**Sydney Children's Hospital Stage 1 and
Children's Comprehensive Cancer Centre (SSD-10831778)
Response to submissions**

Attachment 1

SKT003

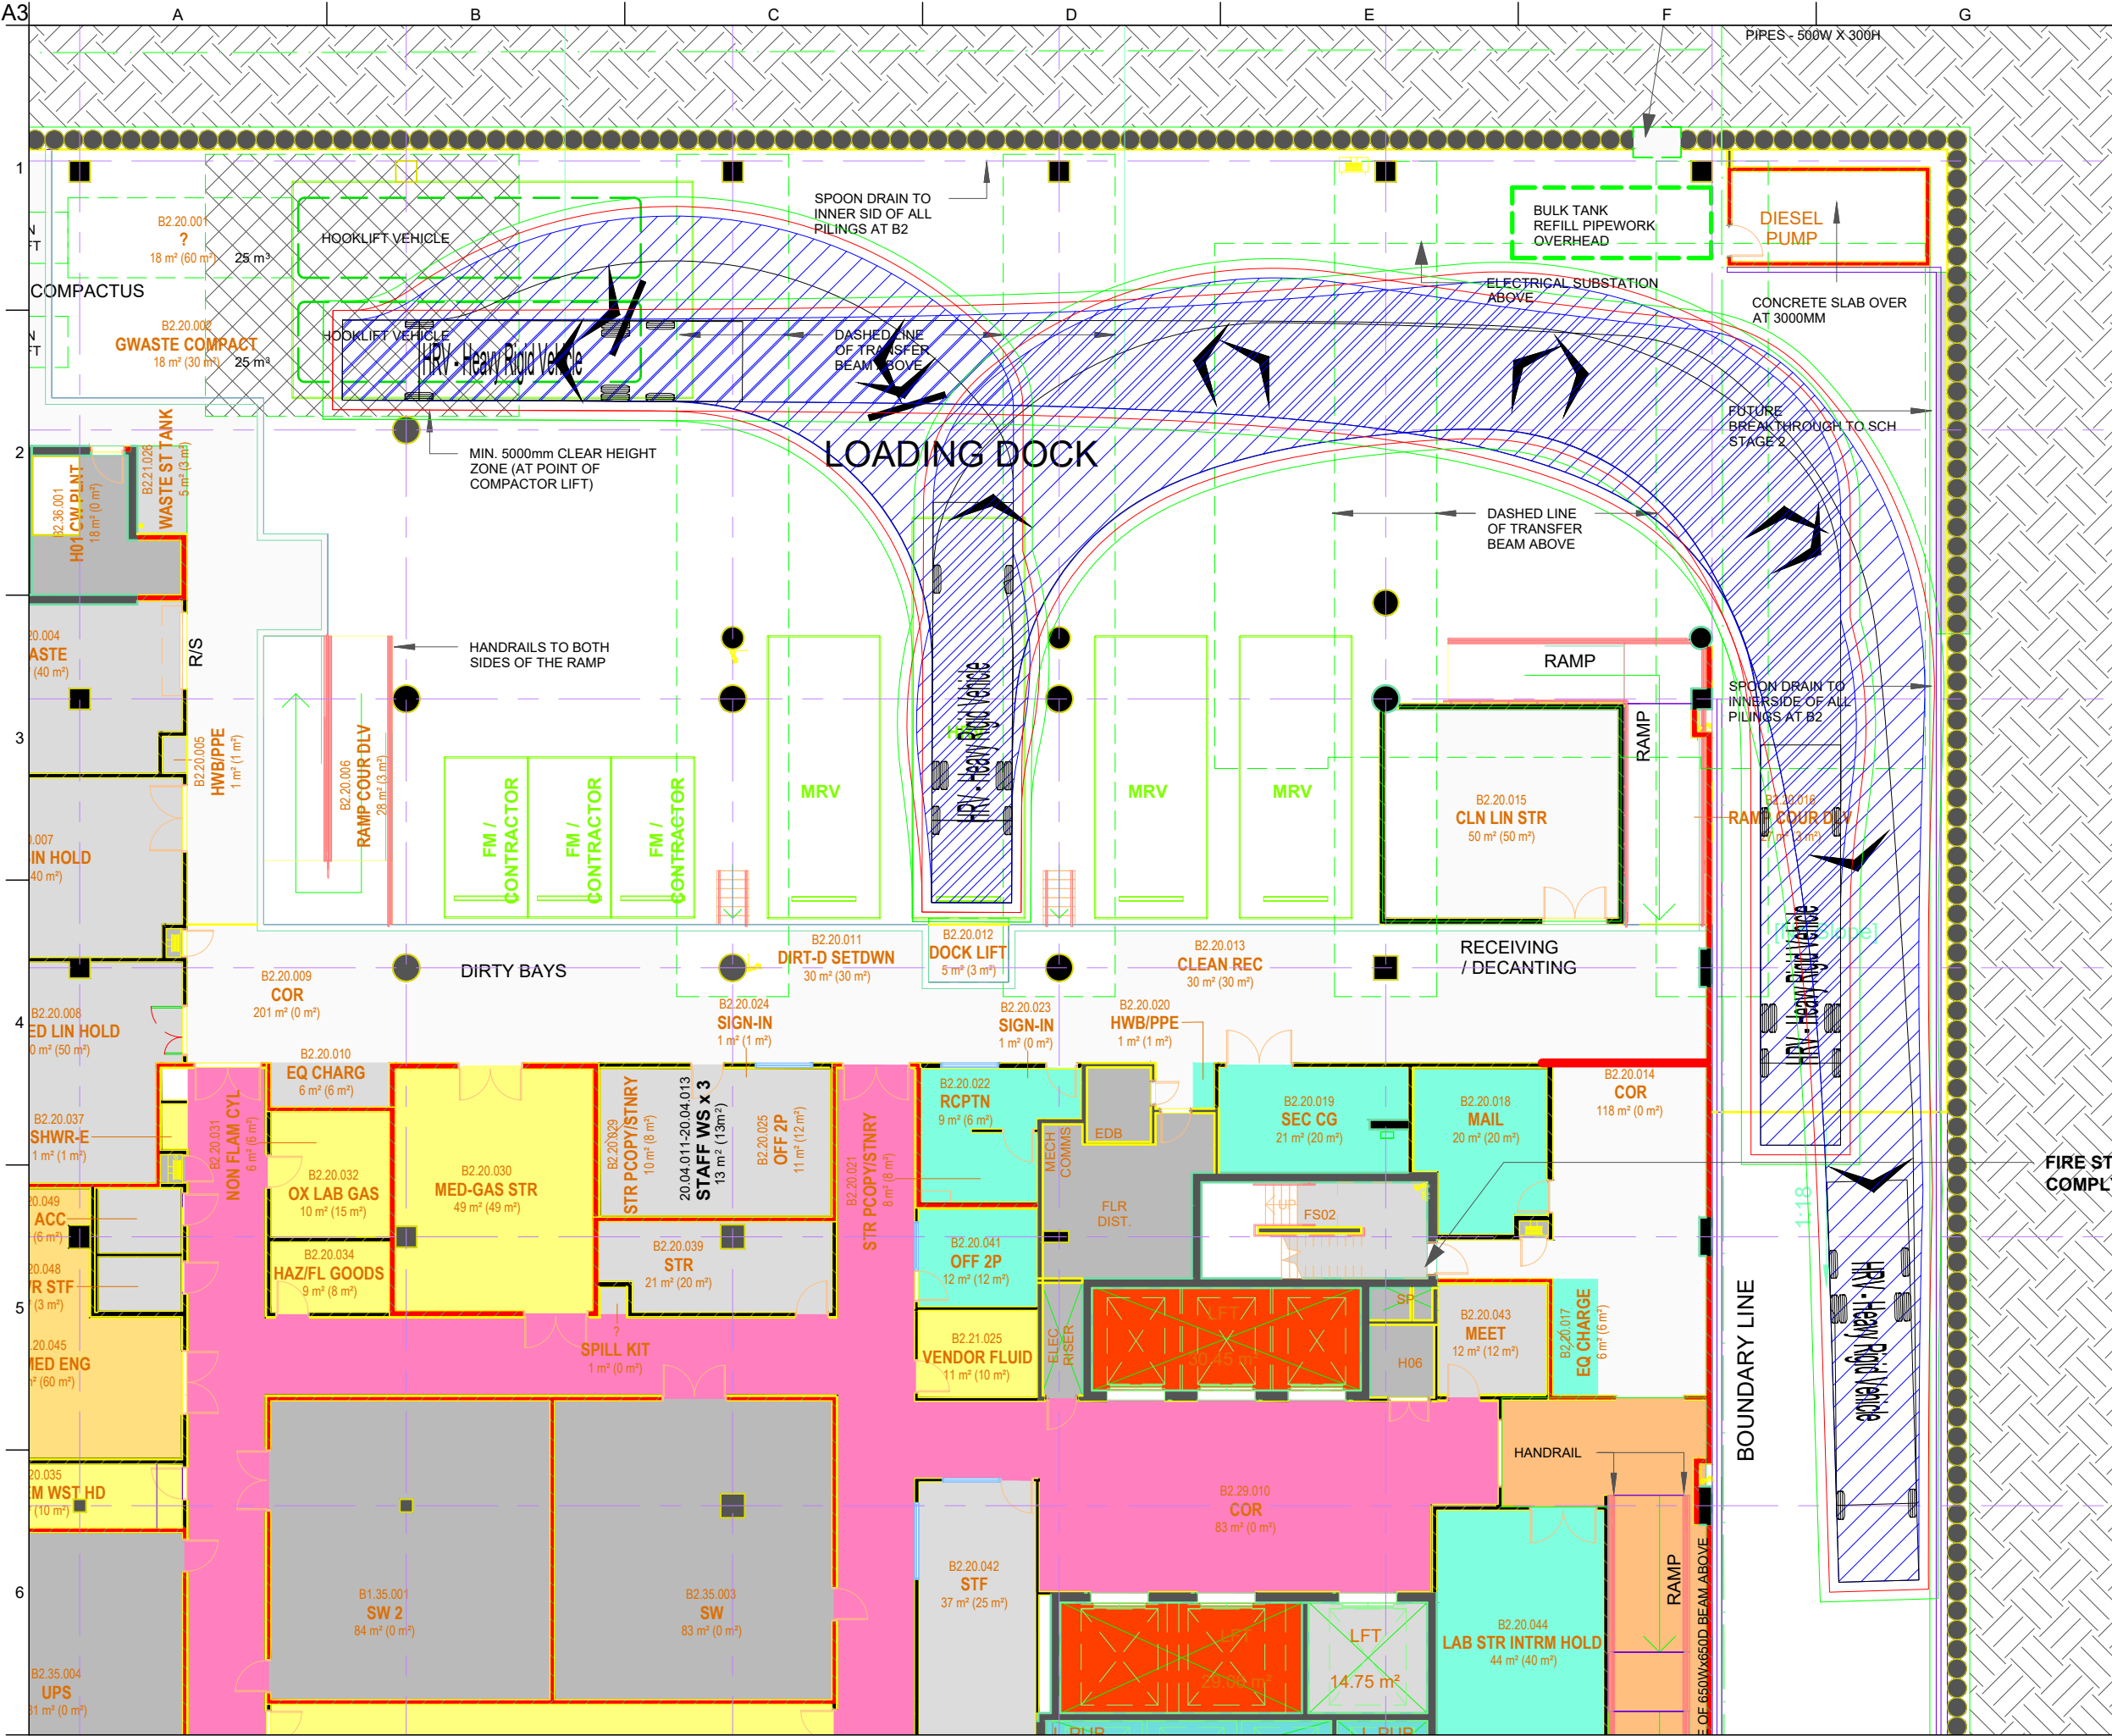
- Provide swept path diagrams and analysis for the largest proposed vehicle types at each vehicle entrance and loading bay area. Where necessary, revise the design to ensure swept paths are appropriate.
- Provide sections for all vehicle access ramps (including the enclosed Hospital Road) demonstrating adequate clearances are provided the largest proposed vehicles in accordance with AS 2890.
- Provide specific details of the proposed dynamic wayfinding system to be implemented in the main carpark and confirmation if, and how, these measures will be delivered to support the proposed development.
